27 January 2023

**GQ Parramatta – Proposed Mixed Use Development SSD-35609161
12 Hassall Street, Parramatta (Site)**

NSW Police Force (NSWPF) Submission on Applicant Additional Information

2 FACADE DETAIL - NORTH ELEVATION
1 : 20

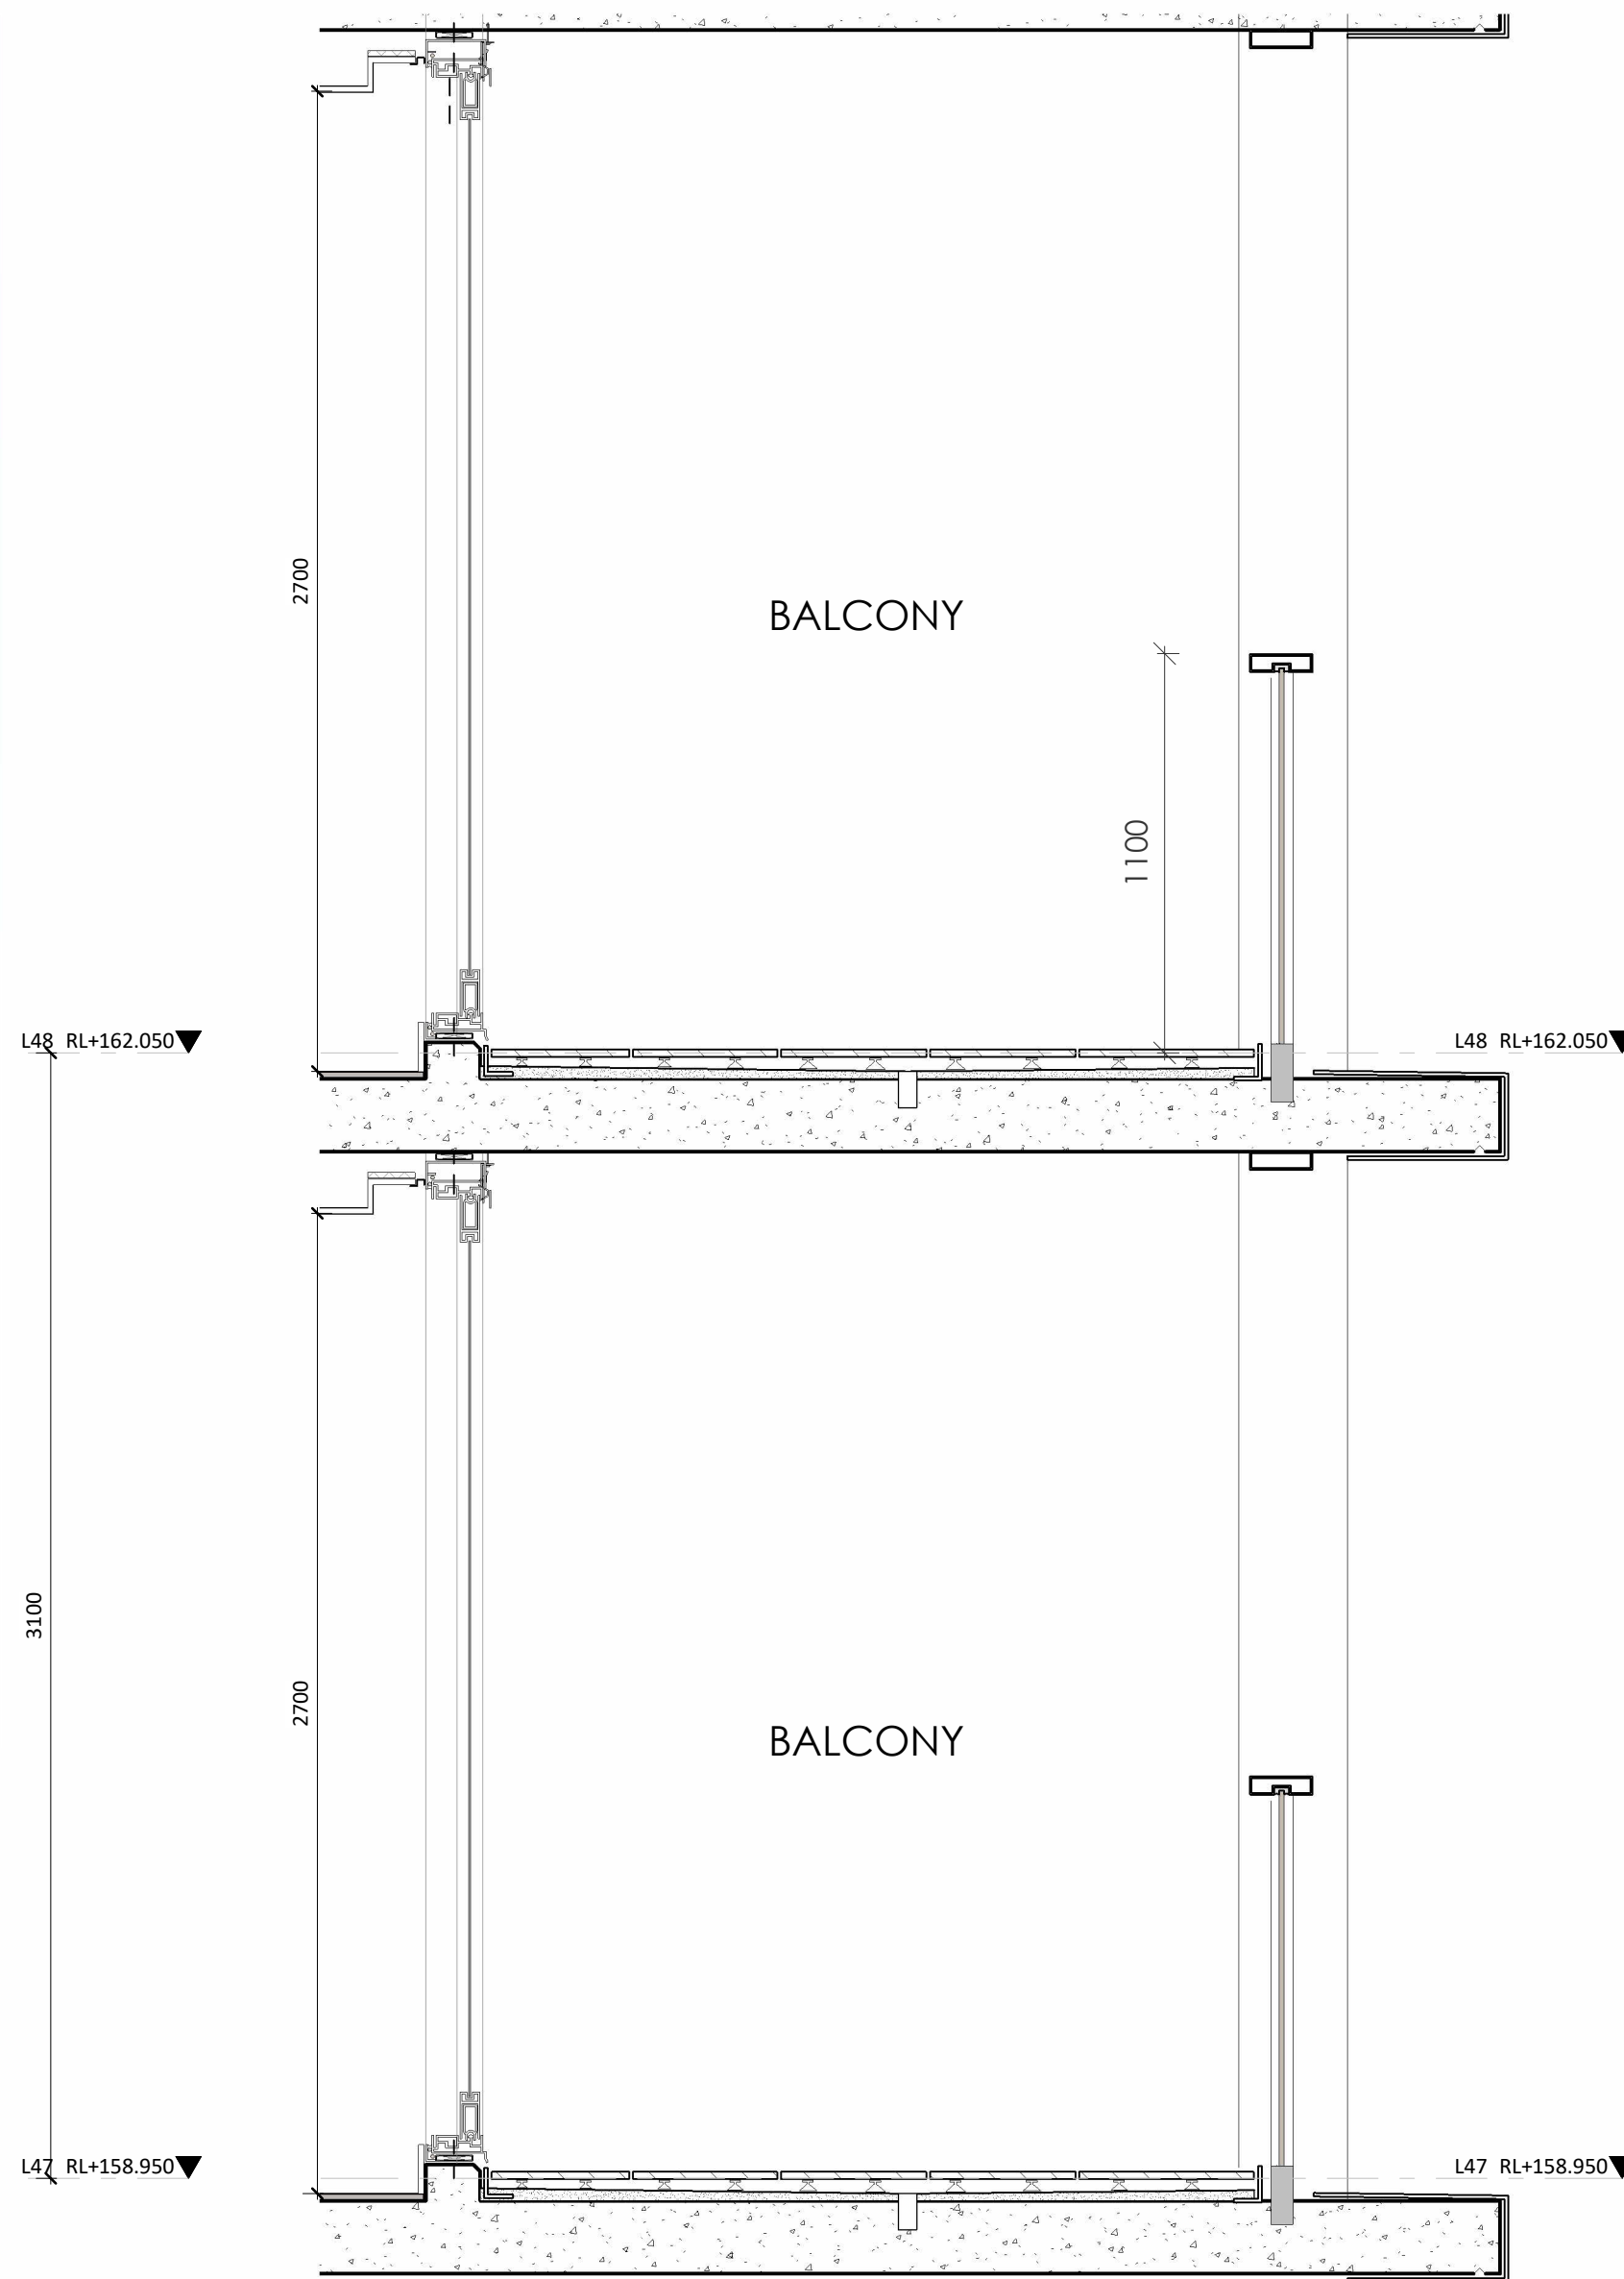
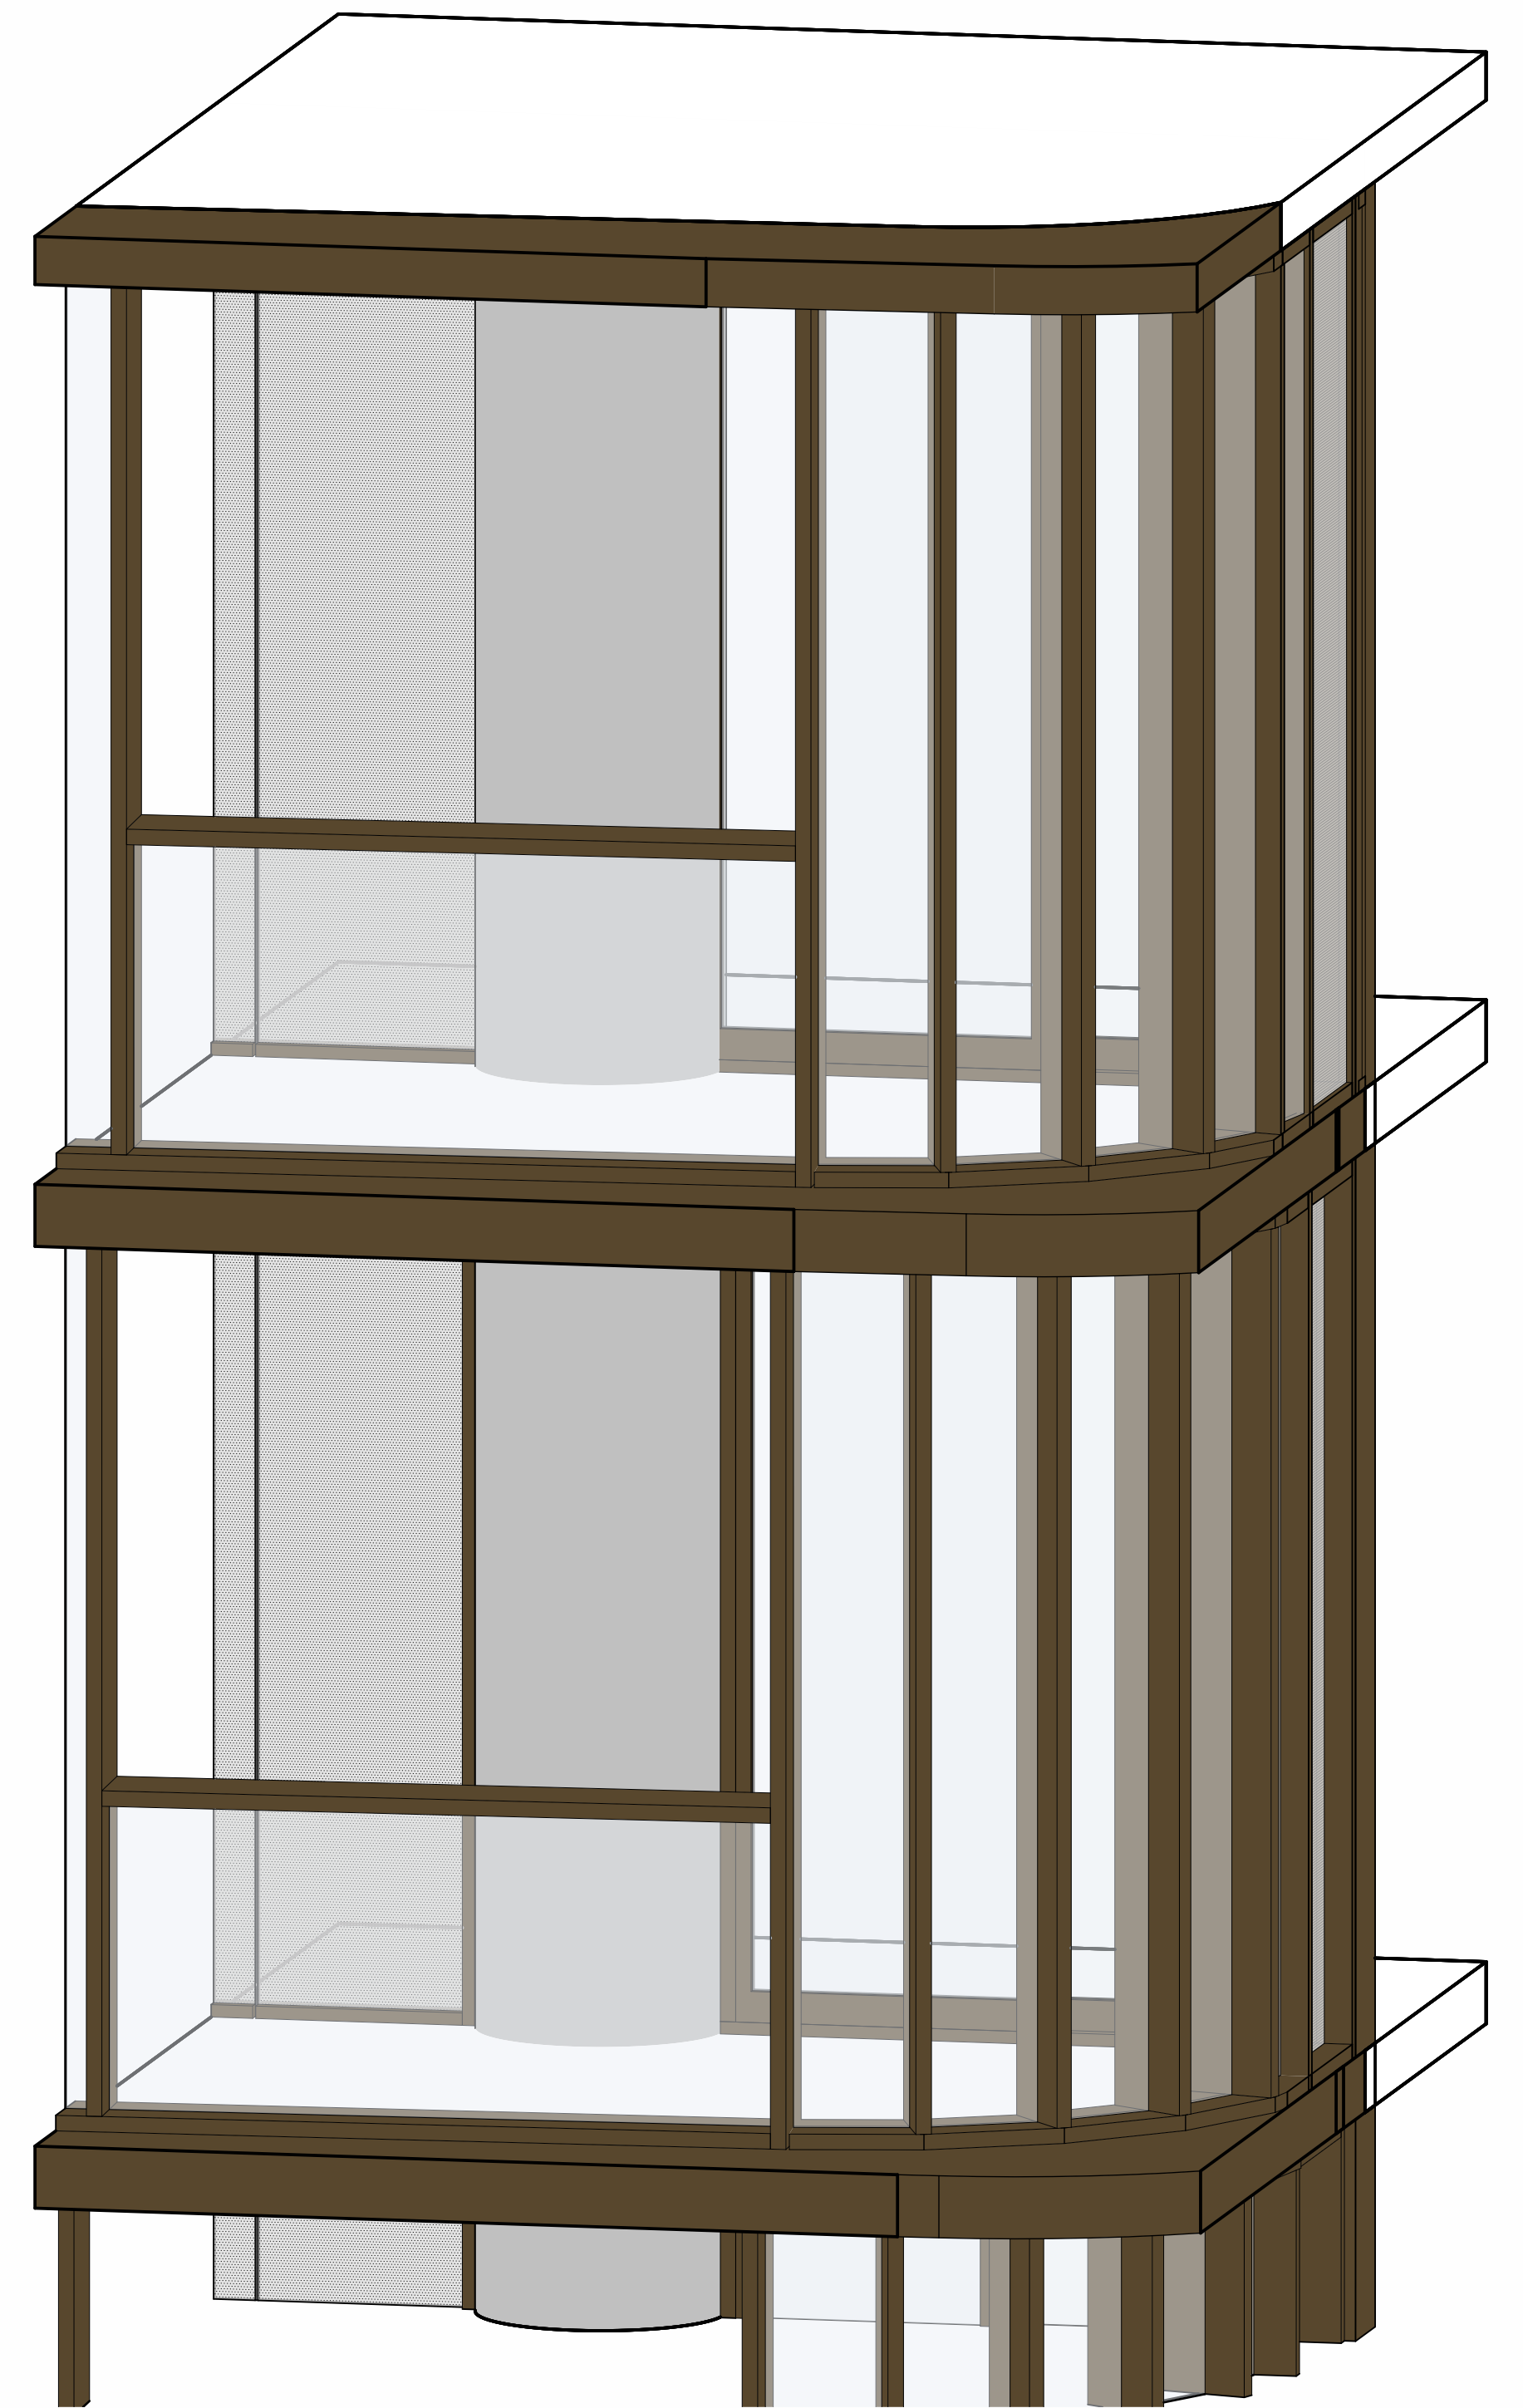
- 35 The Applicant has proposed architectural amendments to the northern façade of its development. According to the Applicant's Addendum Submissions Report, these comprise:

- (1) on Levels 1 to 3 – fixed aluminium louvres angled to 45 degrees in a north east direction; and
 - (2) on Levels 5 to 14 – a combination of graded density fritted glass (for windows) and angled frosted louvres (for balconies).

- 36 NSWPF has not been provided with any visual analysis that models the effectiveness of these screening treatments on line of sight from the Proposed Development into PHQ. Prima facie, however, they would appear to reduce the potential for visual surveillance of PHQ and the risk of projectiles emanating from the northern side of Levels 1-3 and 5-14 of the Proposed Development.

- 37 That said, NSWPF has reservations about some aspects of the proposed screening mitigation. The Level 4 podium terrace is not addressed by it. There the Applicant seems to be relying on landscaping. The plans also contain ambiguous notations as to whether the screening is to 'L13' or 'L14', which should be clarified. NSWPF submits that the screening ought to extend at least to the level above the roof top of 1 Charles Street. Limiting it to Level 14 of the Proposed Development would still leave PHQ vulnerable. Moreover, NSWPF requires that there be frosted glass and angled fixed louvres to at least one level above the PHQ roof so as to prevent viewing into NSWPF offices and the potential for projectiles from the Proposed Development which has previously been verbally agreed between the Applicant and the NSWPF.
